16 April 2018
Our Ref: 6131Q.6ER_RFI

Response to submissions
S75W Modification of MP09_0180
Clusters 2, 3 and 4, 34-36 Memorial Avenue, Kellyville

Landscape Concept Plan

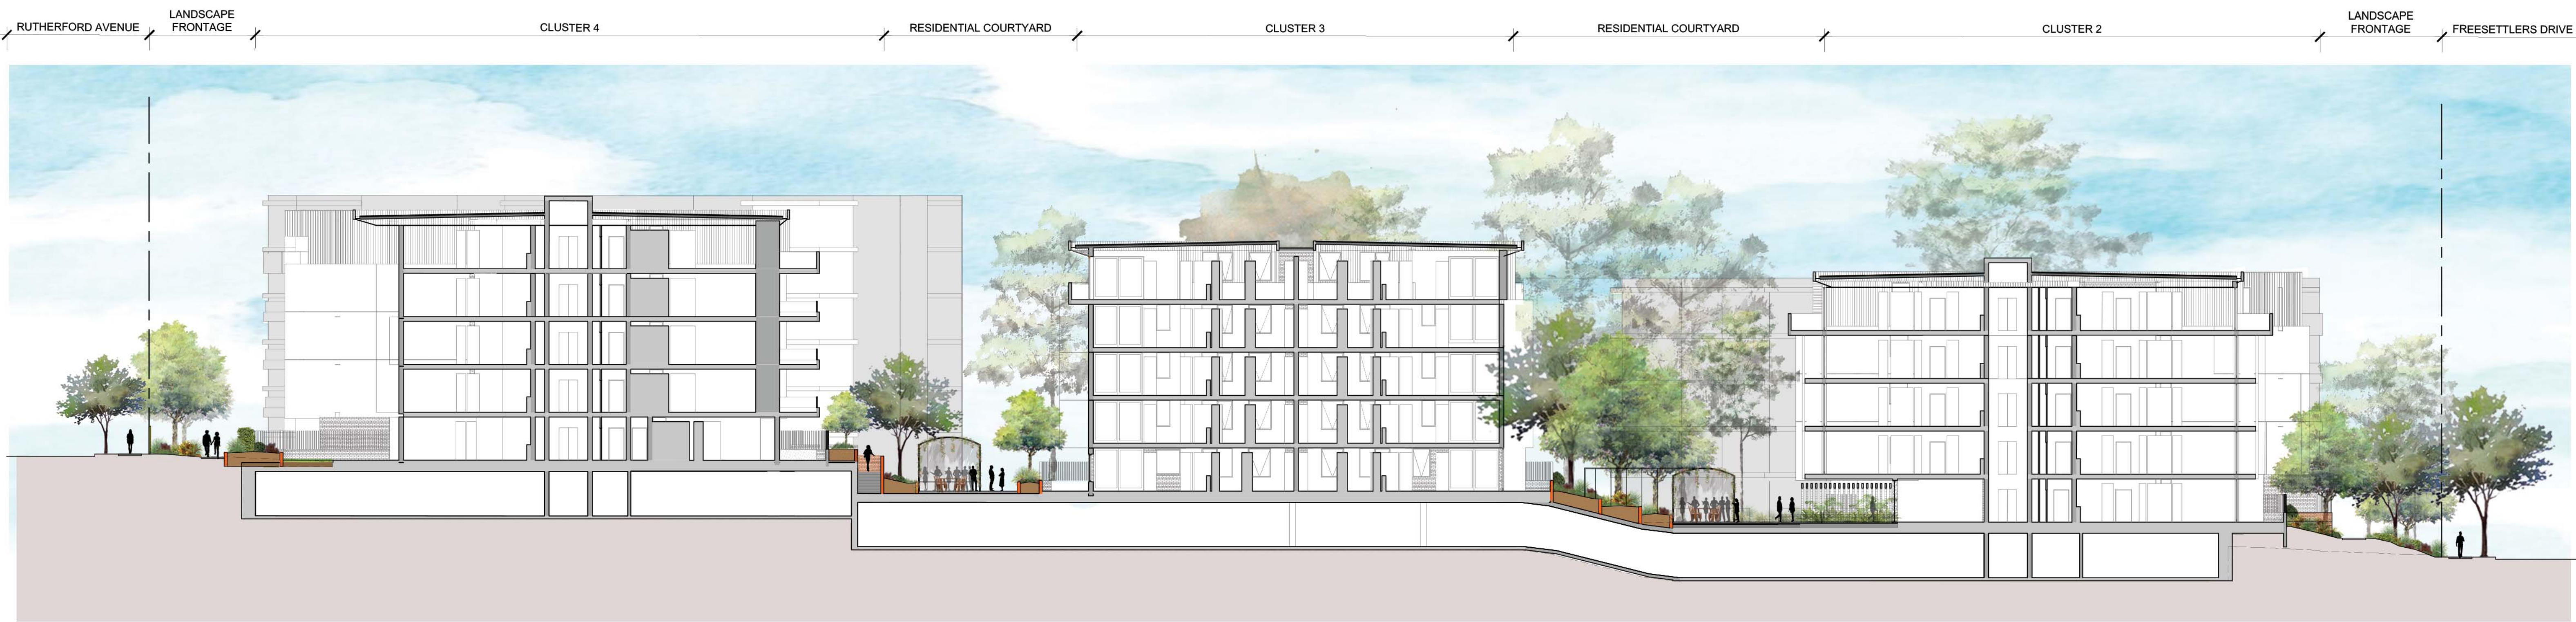
- The separations between the buildings in Stage 3 and the existing development is sufficiently wide enough to provide dense landscaping, including tree planting, as demonstrated in the Landscape Concept Plan at Appendix 3 to the EA report.

- Installation of 23 repurposed natural hollows instead of nest boxes which are already in high density with the reserve.
- To replace damaged or lost nest boxes within the reserve with repurposed natural hollows or nest boxes.
- Planting of a minimum 28 new CPW trees within the CPW open space reserve and 10m defendable zone which achieves a 5:1 offset ratio.
- Harvesting of up to 4 trunk sections 3-4m in length to be relocated onto the CPW reserve for on-ground habitat.
- Implement monitoring of the nest boxes and hollows.
- Update the Landscape Restoration Management Plan and landscape plans to reflect the above outcomes.

01 Cluster 4 Level 4  
1:100

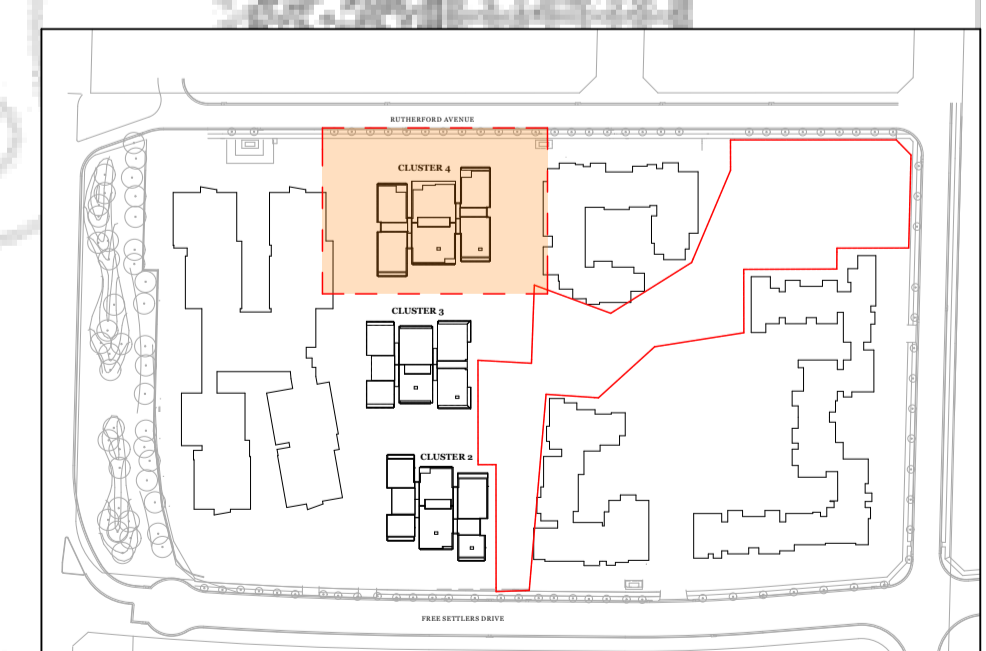
- The separation between the upper levels of Cluster 4 and the existing Cluster 5 building is 17.6m which is 5.6m more than the minimum 12m separation for the first 4 storeys and only 400mm less than the minimum separation for the upper storey. The larger than recommended separation between these two buildings has resulted in a better outcome in terms of solar access for residents in Cluster 5, compared to the approved building layout for the site, as demonstrated in the comparative shadow diagrams submitted with the application.
